Rezoning Transportation Analysis

Petition Number: 2022-193

Date	Description
3-22-23	First Review (TM)

SHEET NUMBER
RZ-01

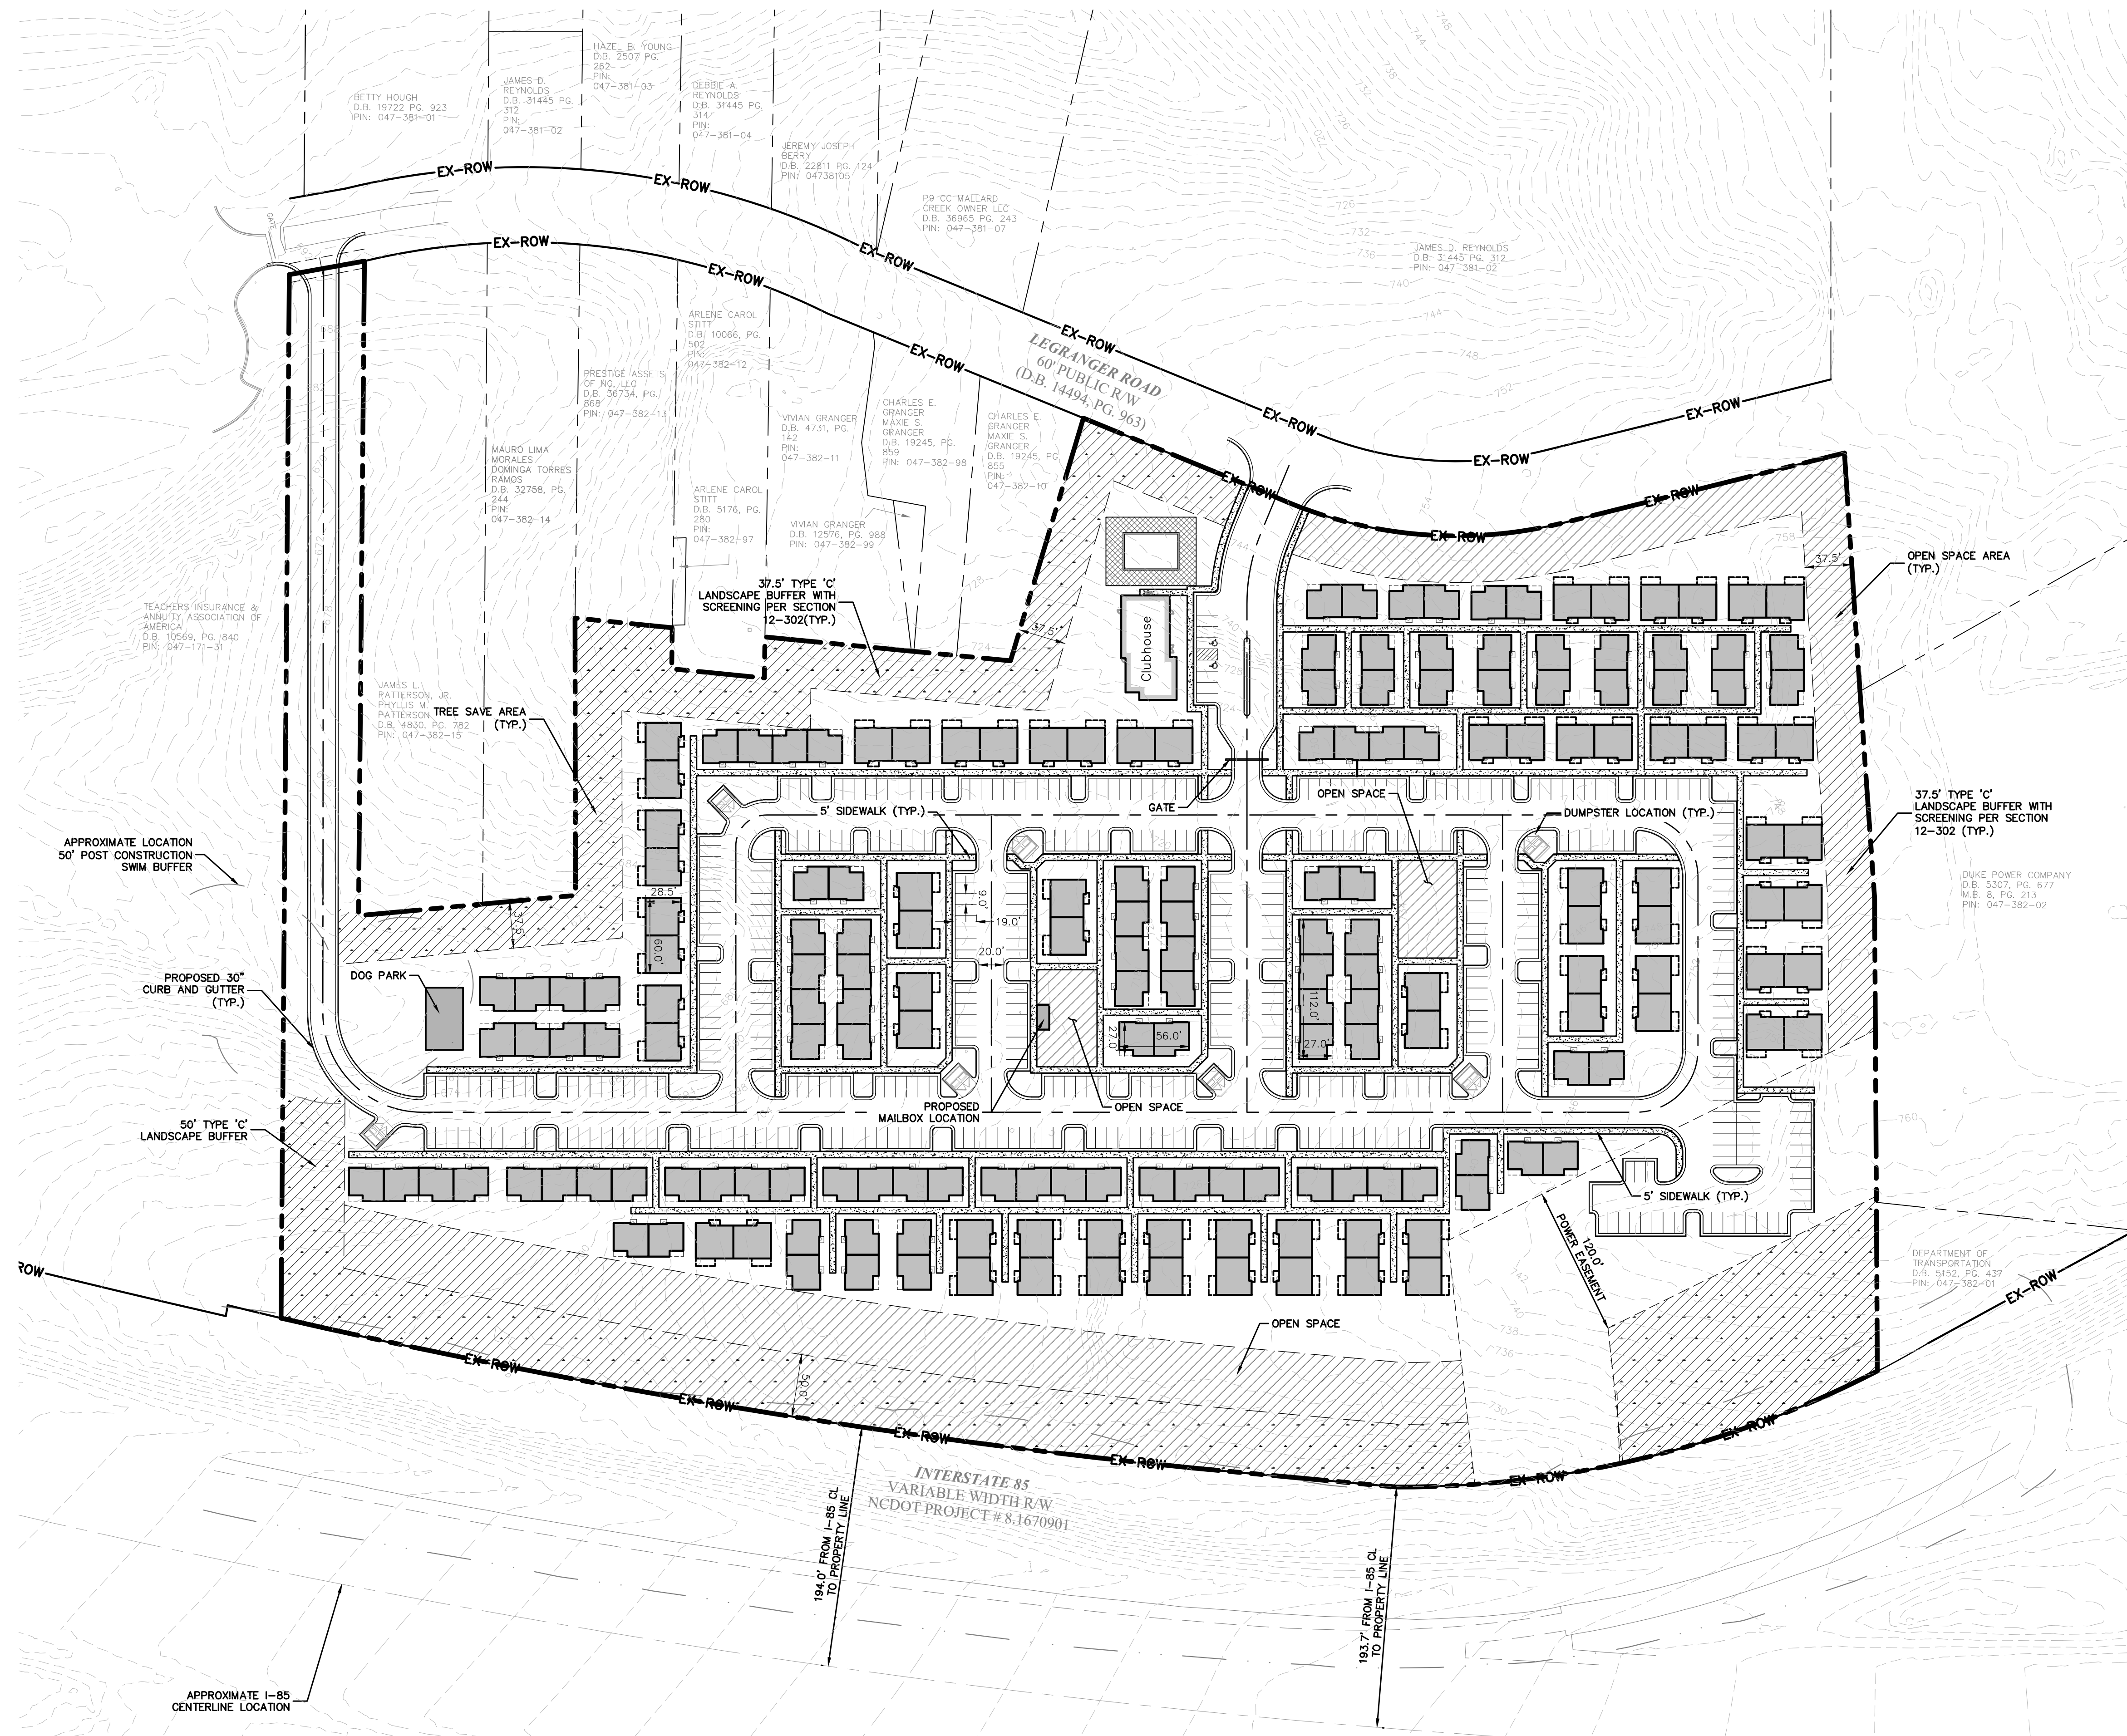
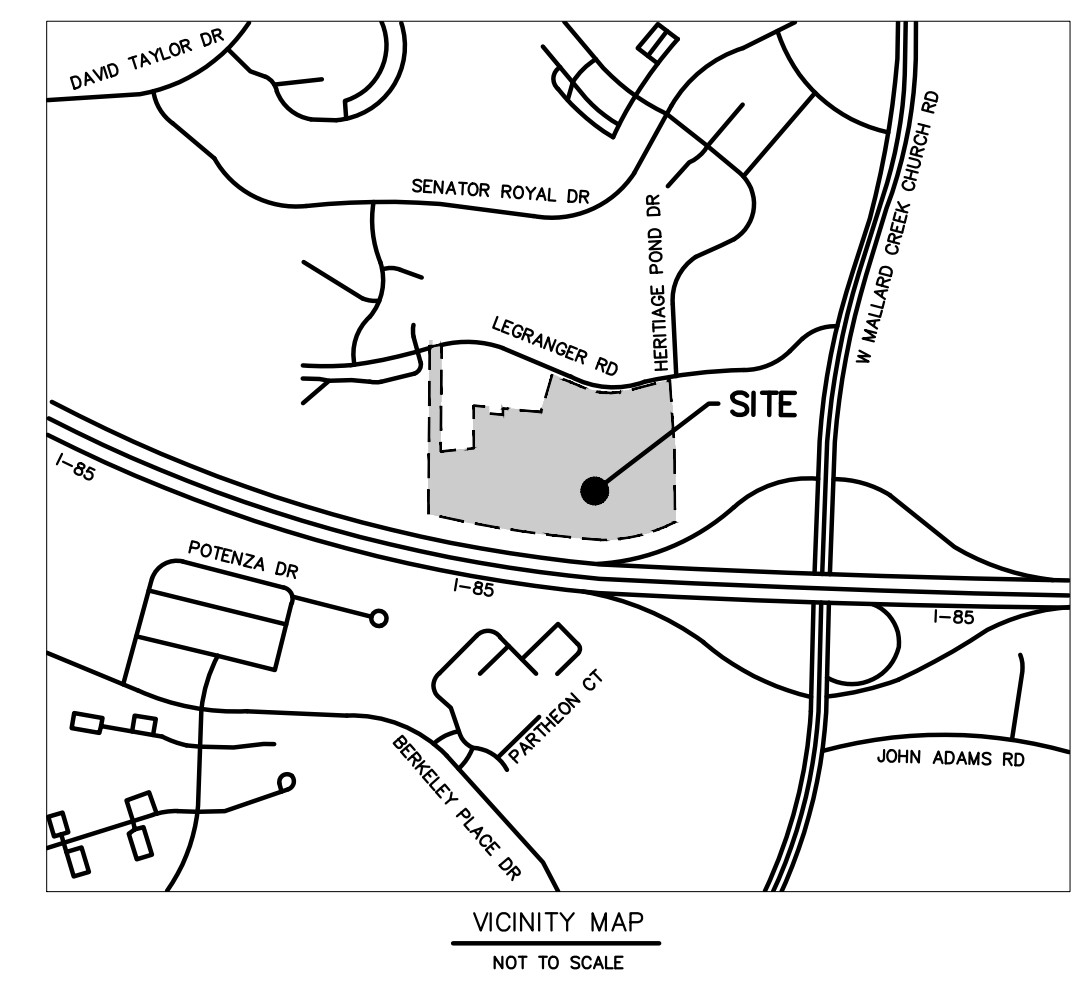
- a. **Legranger Road:** Location of curb and gutter to be 13 feet from roadway centerline to accommodate a roadway typical section matching Charlotte Land Development Standards Manual (CLDSM) U-02.

Label and dimension the curb and gutter from the centerline for each road on the site plan.

- 3. Revise site plan and conditional note(s) to commit to dedicate a minimum of 28' right-of-way from the road centerline. The site plan shall label and dimension the right-of-way from the road centerline.
- 4. Revise site plan and conditional note(s) to commit to construct an 8-foot planting strip, and 6-foot sidewalk on Legranger Road per Chapter 19. The site plan shall label and dimension both items from the back of curb and gutter or edge of pavement.

5. Revise site plan and conditional note(s) to commit to reconstructing Legranger to meet CLDSM U-02 standards along sites frontage including sidewalk, curb and gutter. Roadway improvements shall be coordinated with adjacent development (SDRU-2022-00007).

6. **CDOT REQUEST 03-23-23:** CDOT request that Legranger is revised to meet CLDSM U-02 between the sites frontage and the proposed site access to plan west. If this section is not complete the western most site access location shall be required to be restricted to emergency vehicular entrance only. This entrance shall be gated with a knox box.
